**EL PASO COUNTY PLANNING AND
 COMMUNITY DEVELOPMENT
 DEPARTMENT**

GRADING AND EROSION CONTROL PLAN CHECKLIST

Revised: July 2019

KEY MAP
 SCALE: NTS

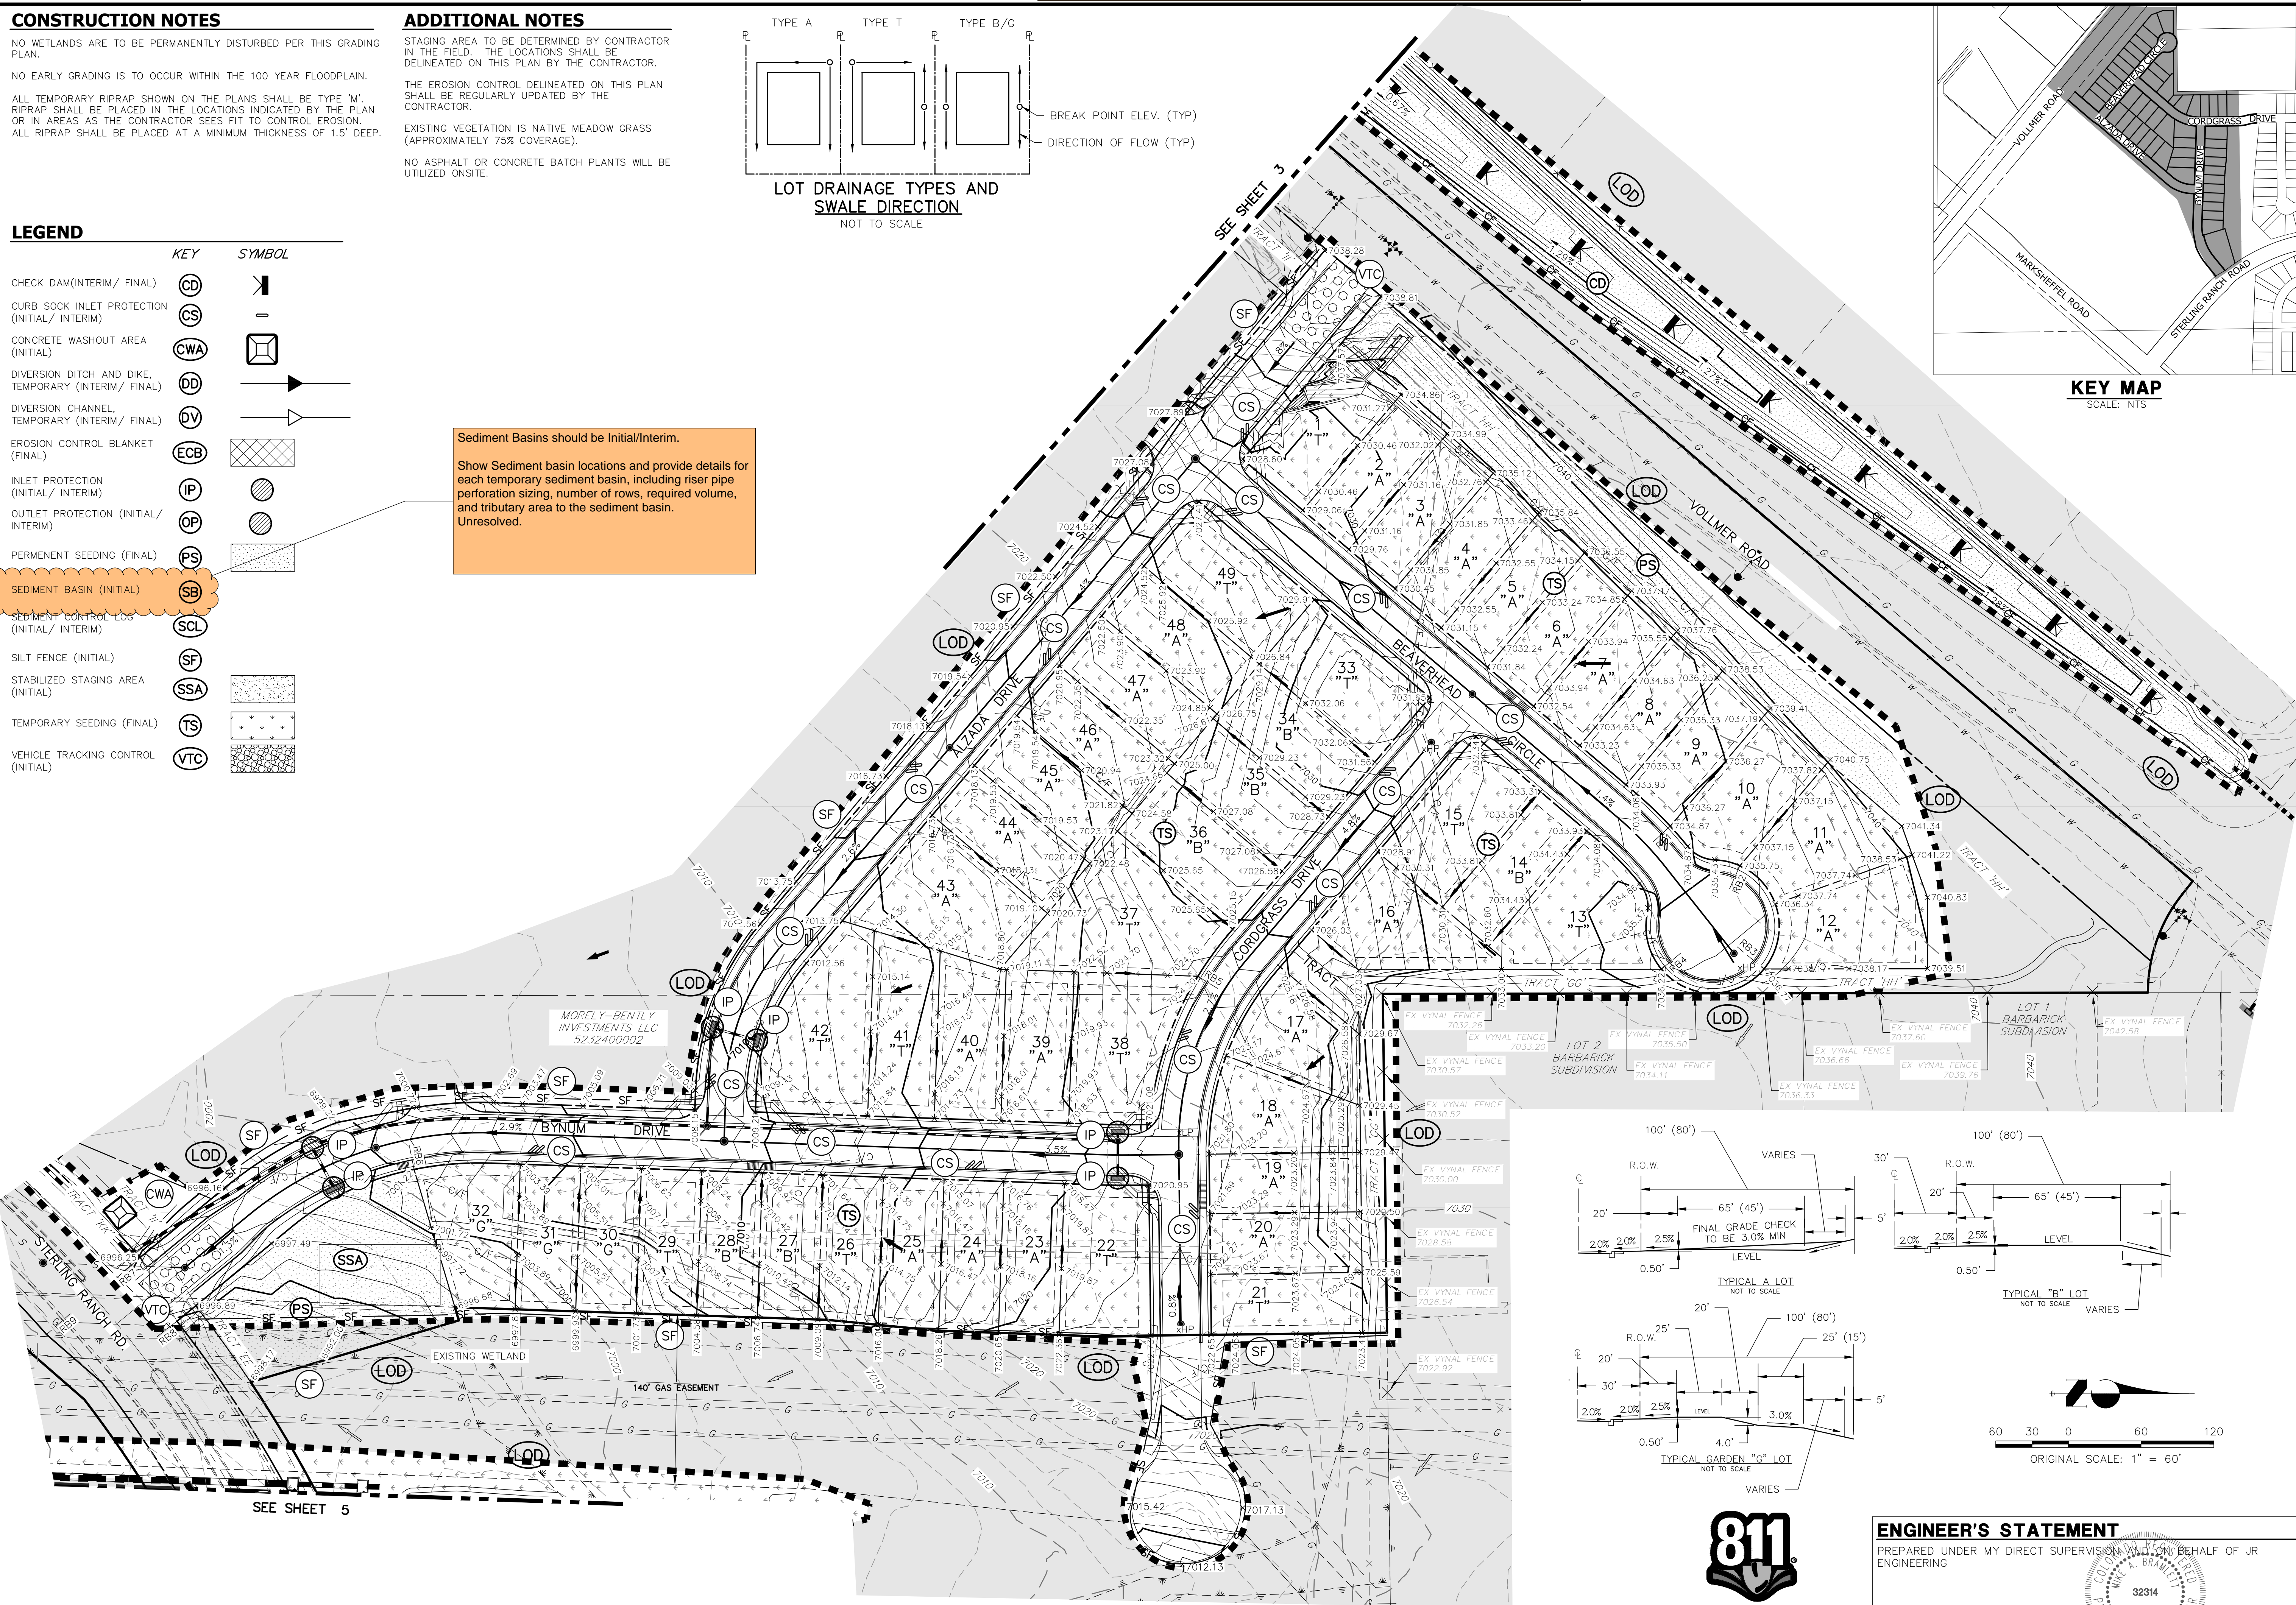
v	All proposed temporary construction control measures, structural and non-structural. Temporary construction control measures shall be identified by phase of implementation to include "initial," "interim," and "final" or shown on separate phased maps identifying each phase.	✓	✓
w	Vehicle tracking provided at all construction entrances/exits. Construction fencing, barricades, and/or signage provided at access points not to be used for construction.	✓	✓
x	Temporary sediment ponds provided for disturbed drainage areas greater than 1 acre.	✓	✗
